Addendum No. 1

RE: Contract # C204902
WBS # 15BPR.102.3
STATE FUNDED
New Hanover County
CAPE FEAR MEMORIAL BRIDGE.

November 21, 2023 Letting

REVISIONS						SHEET NO.
NO.	BY:	DATE:	NO.	BY:	DATE:	TOTAL SHEETS
1			3			21
2			4

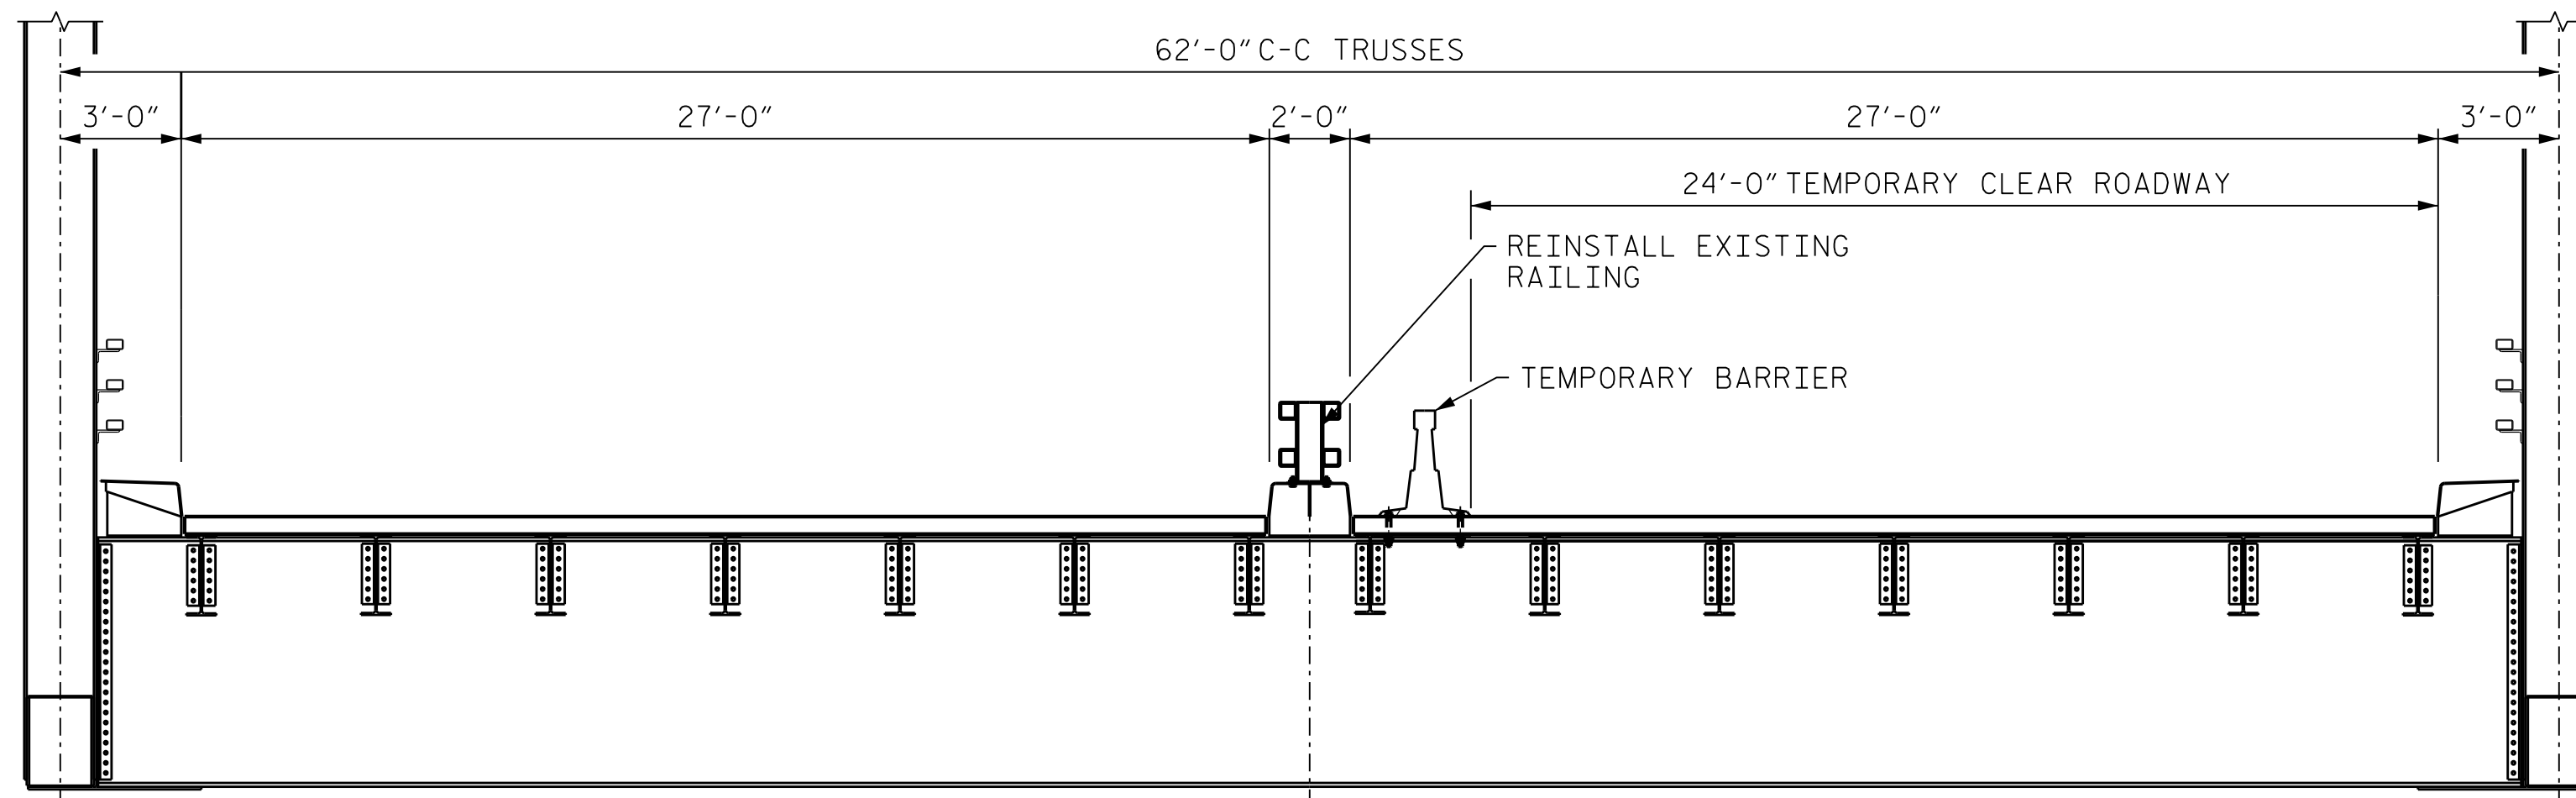
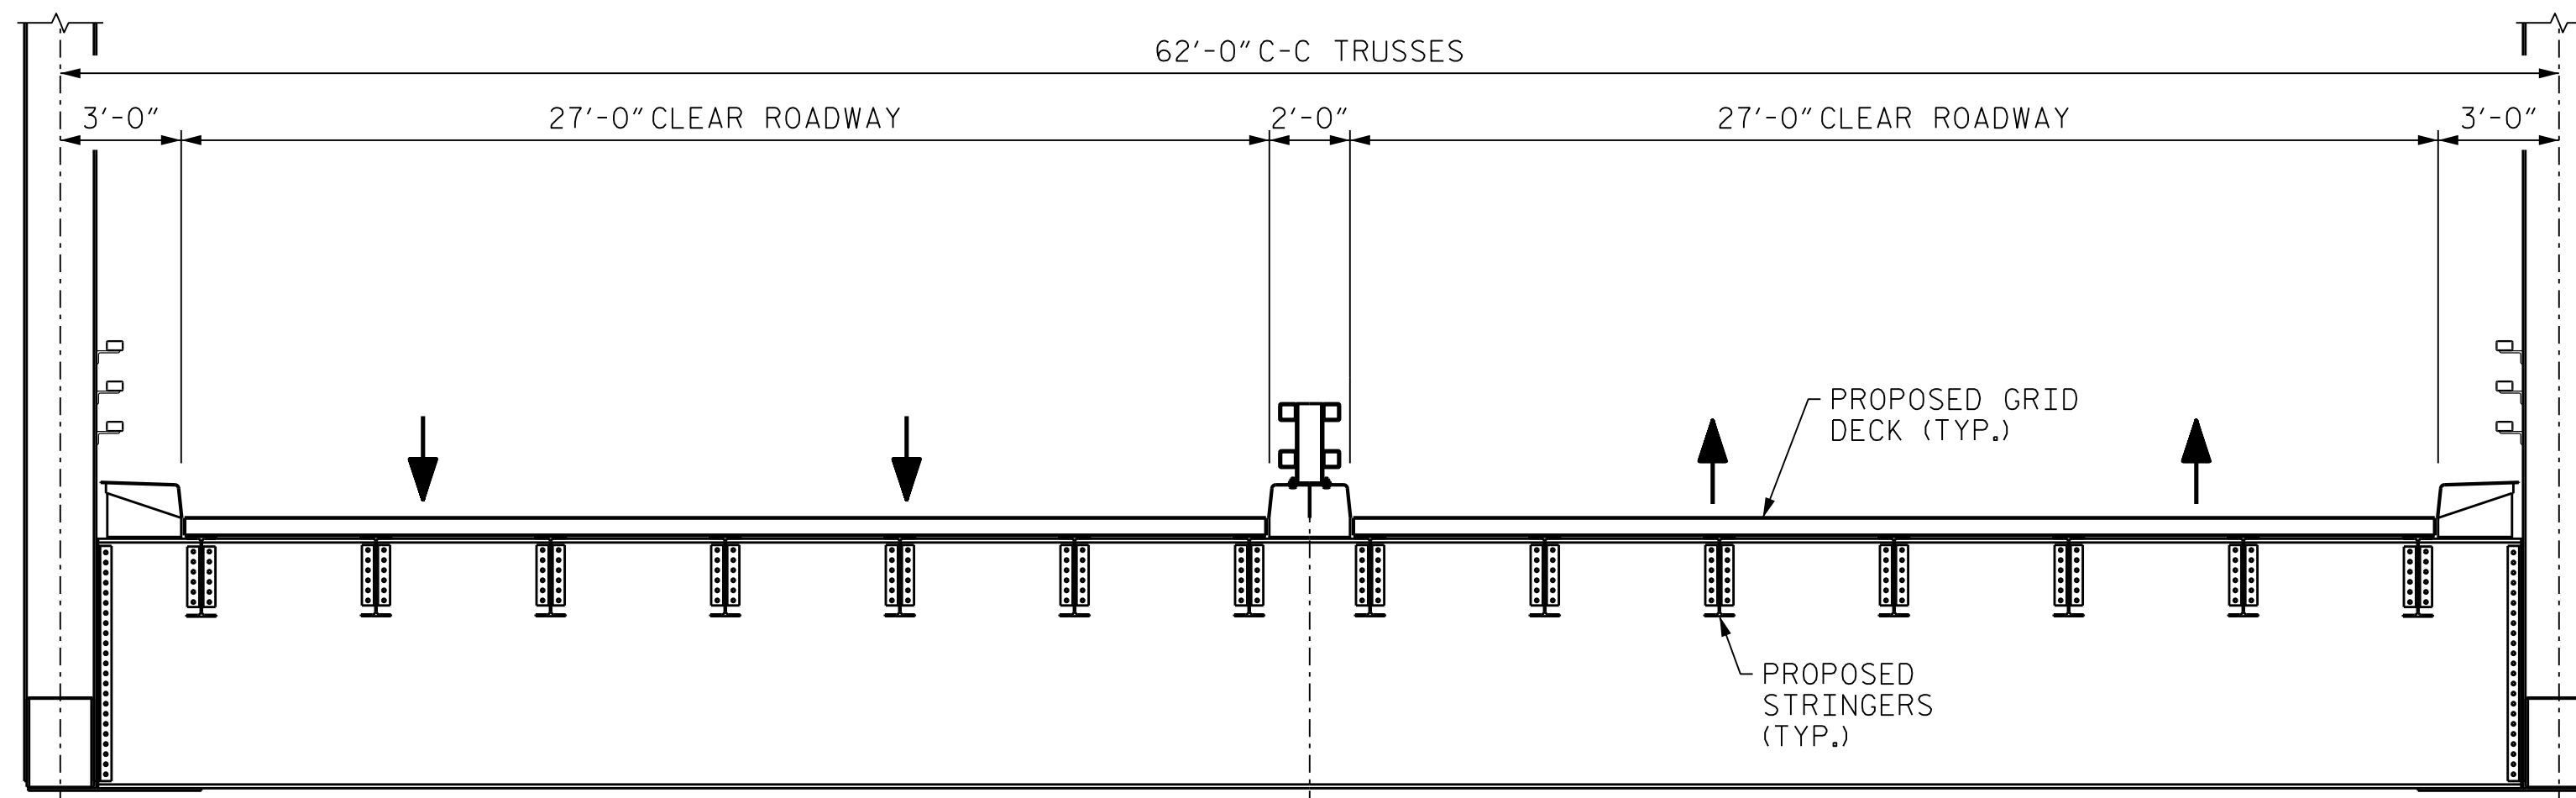
Sheet No.	Revision
S-5, S-6, S-15, S-17	Revised to indicate that the eastbound side of the bridge grid deck and structural steel is to be done first and to indicate that temporary bracing must be installed to facilitate opening the bridge while Stringers S2, S13, S7, and S8 are removed.
